City of Portland, Maine - Building or Use Permit Application

Permit No: 05-0306	Issue Date: APR 13 2005	ISS: CBL: 091 A003001
-----------------------	----------------------------	--------------------------

Douglas Cottage
Tolman Heights
Peaks Island, Maine

ADDENDA #1

4 SECTION thru STAIR & LANDINGS
 SCALE: 1/2" = 1'-0"

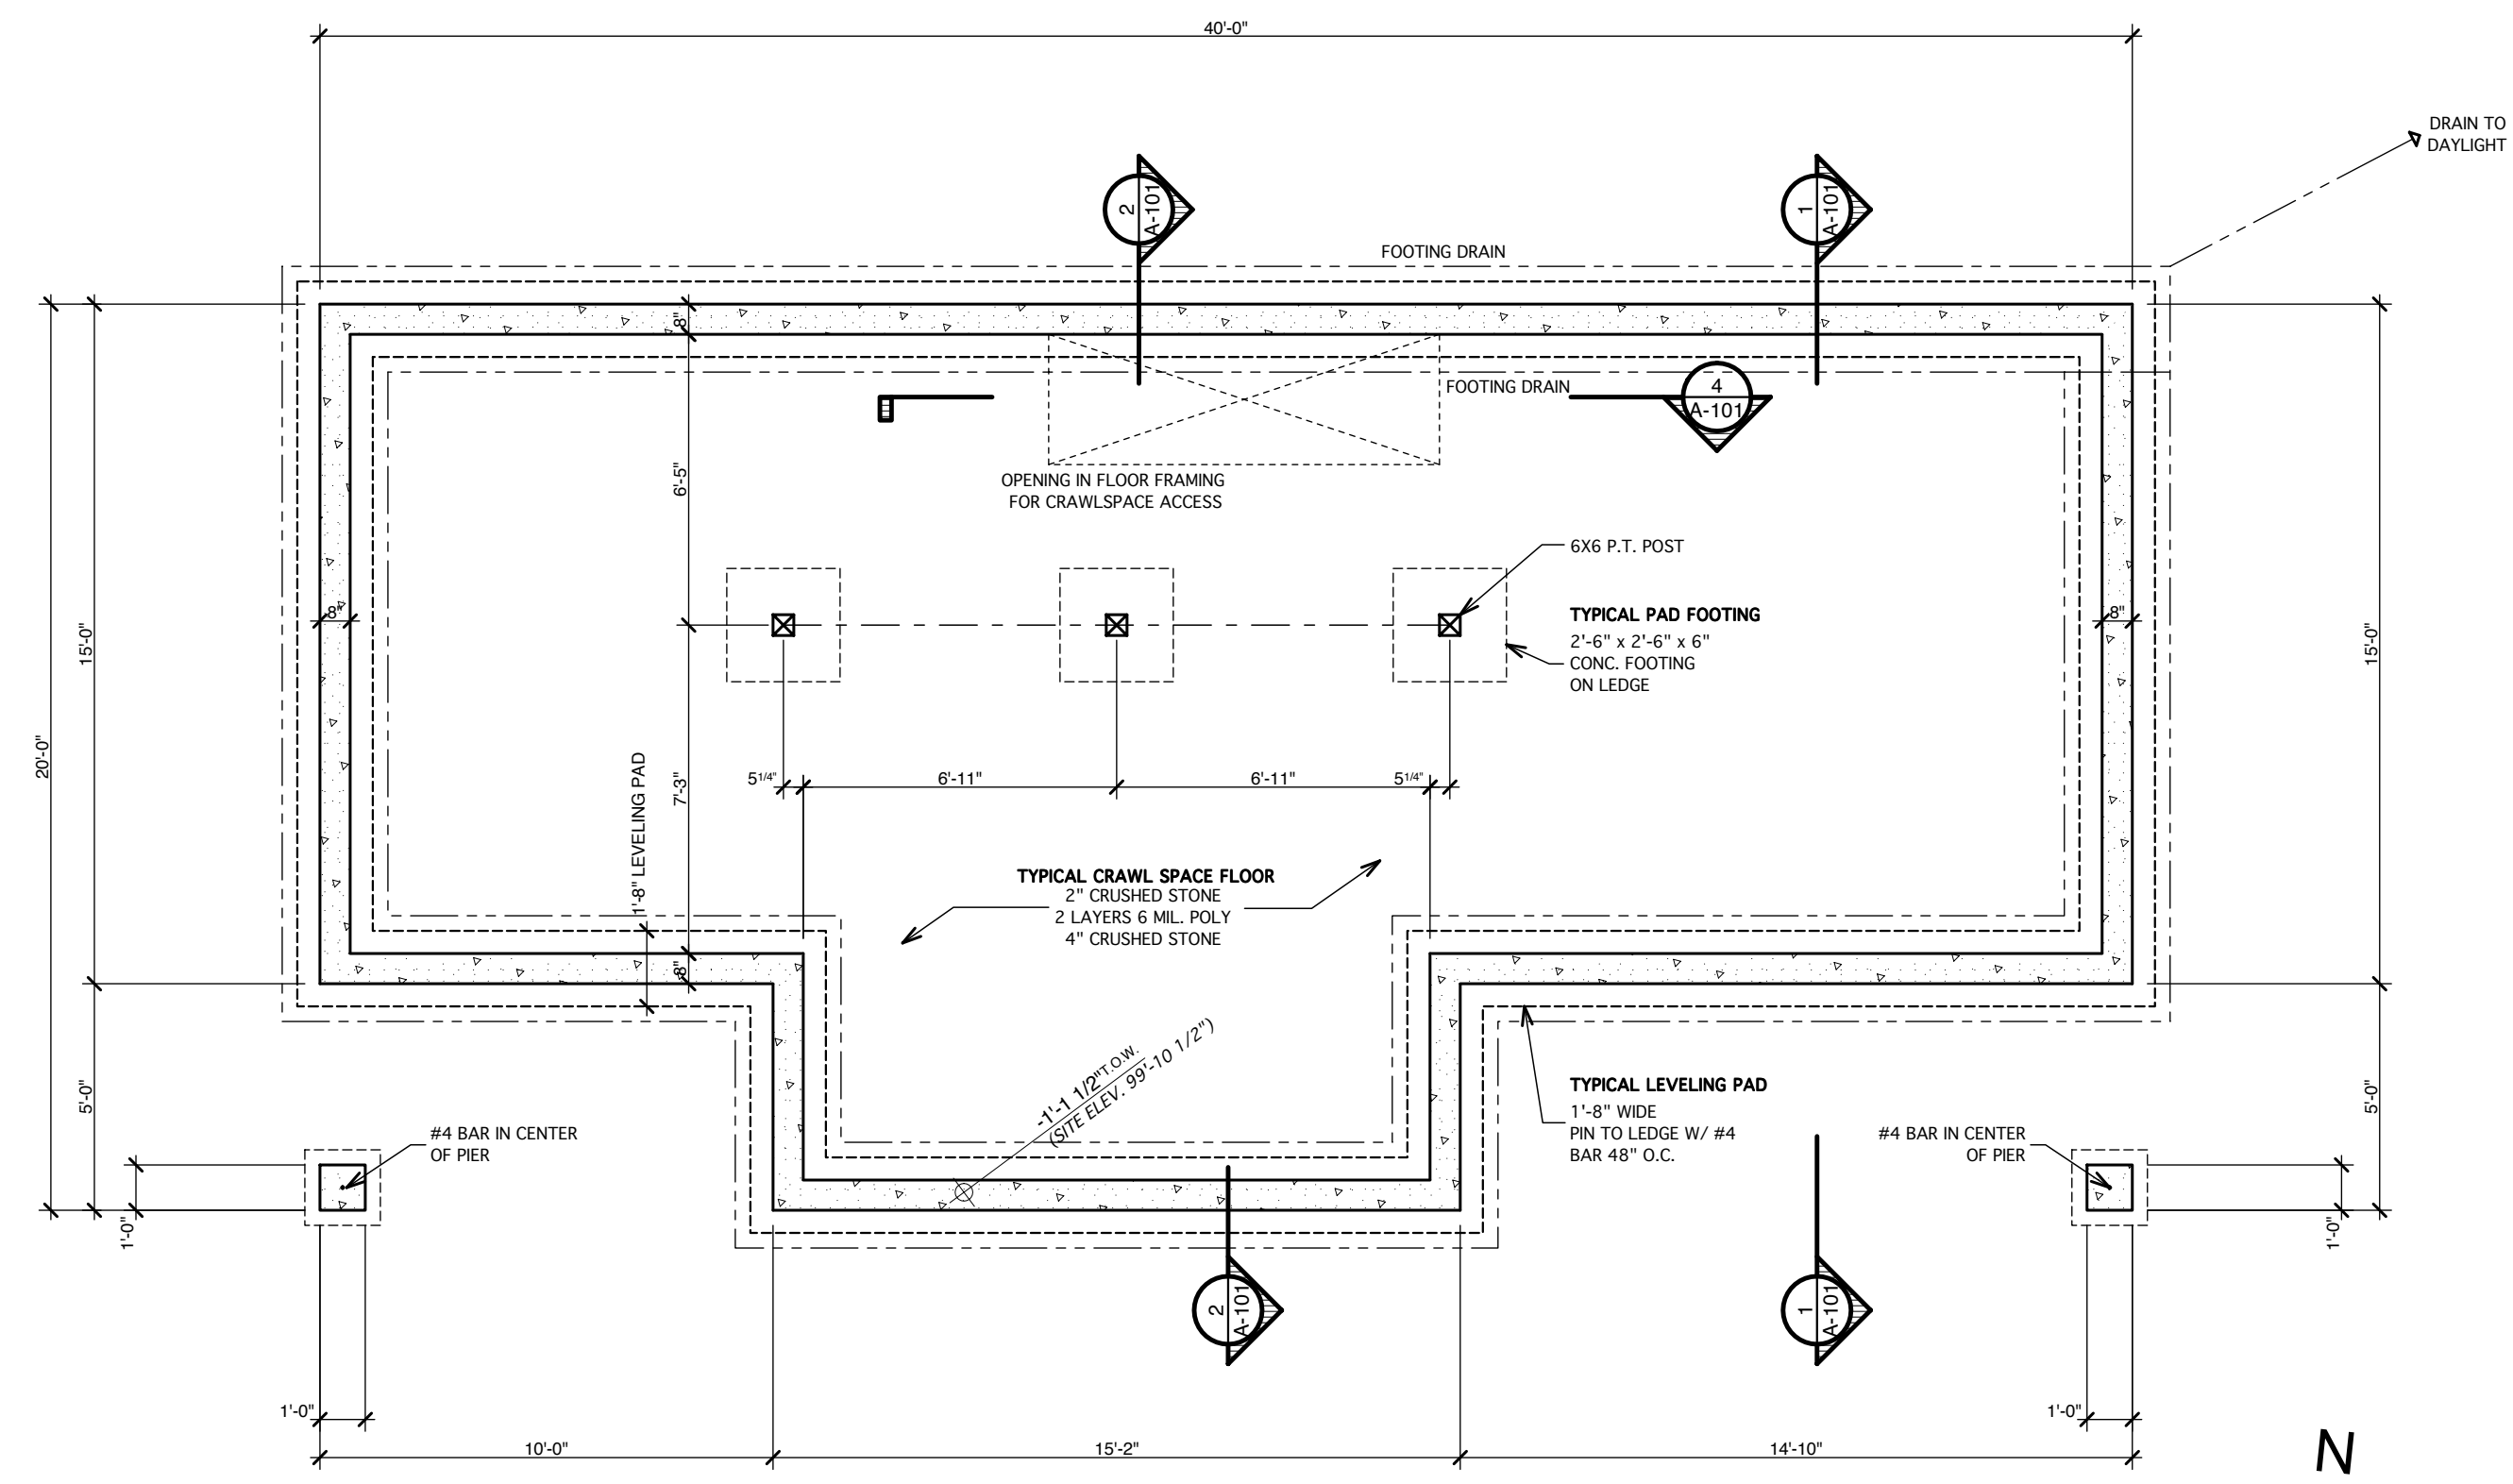
5) Headroom in bath 6' @ Toilet - OK

Railing Height: Railing indicated to be 36" AFF. See attached drawing "Revised Section thru Stair & Landings."

Clearance at Toilet: Headroom increased at toilet. Clearance is 6'-1" above the tank, 6'-9" between face of tank and rear edge of the toilet seat, and 8'-9" for the remainder of the fixture. See attached drawing "Revised Section thru Stair & Landings."

E SECOND FLOOR CANTILEVERED LANDING DETAIL
 SCALE: 1 1/2" = 1'-0"

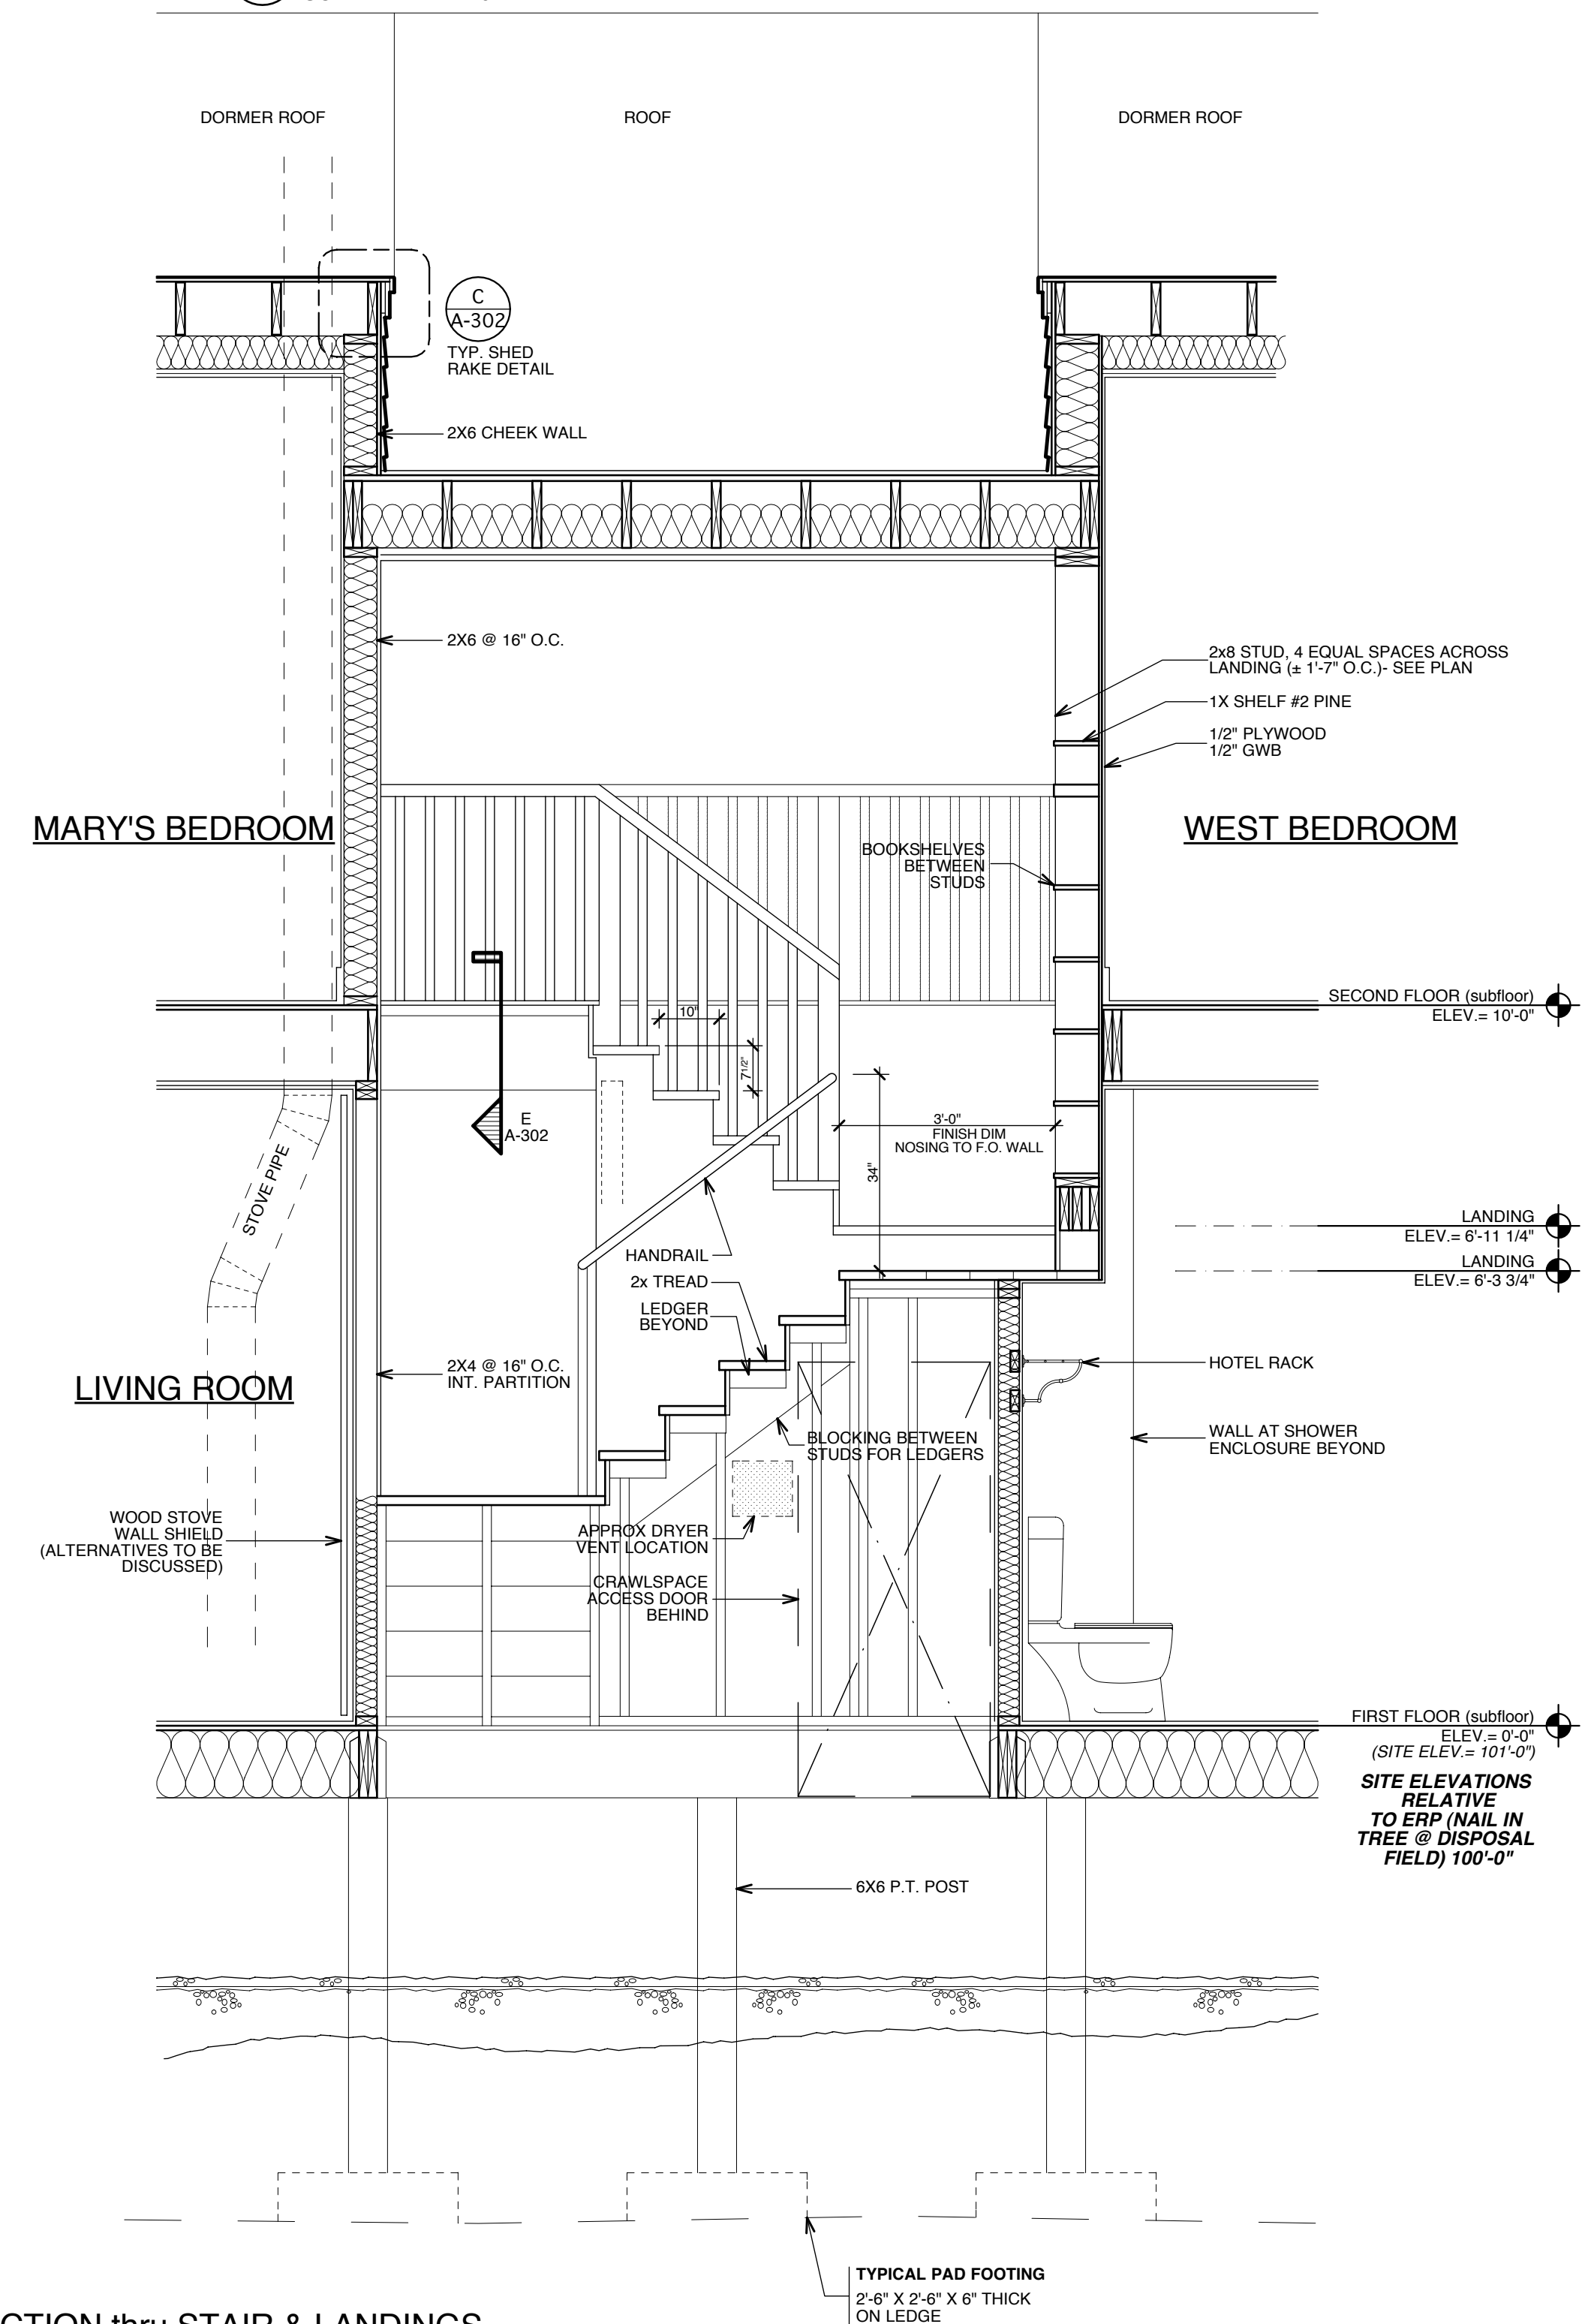
~~Table~~ Tapered & notched 2"x12"-5 C landing - ^{Table 502.3.3(2)} OK - stamped engineering

Cantilever Landing: See attached letter regarding review by our structural engineer.

We analyzed the cantilevered **beam** in question at the 2nd Floor landing in the stairway for the Douglas Cottage on Peaks Island. The beams are 2x12's @ 16" o.c. with a 3'-0" cantilever. The cantilever is haunched to a 6-inch deep beam and then tapered towards the tip. We found that these cantilevered beams are adequate for supporting the residential loads as required per the **IRC 2003**.
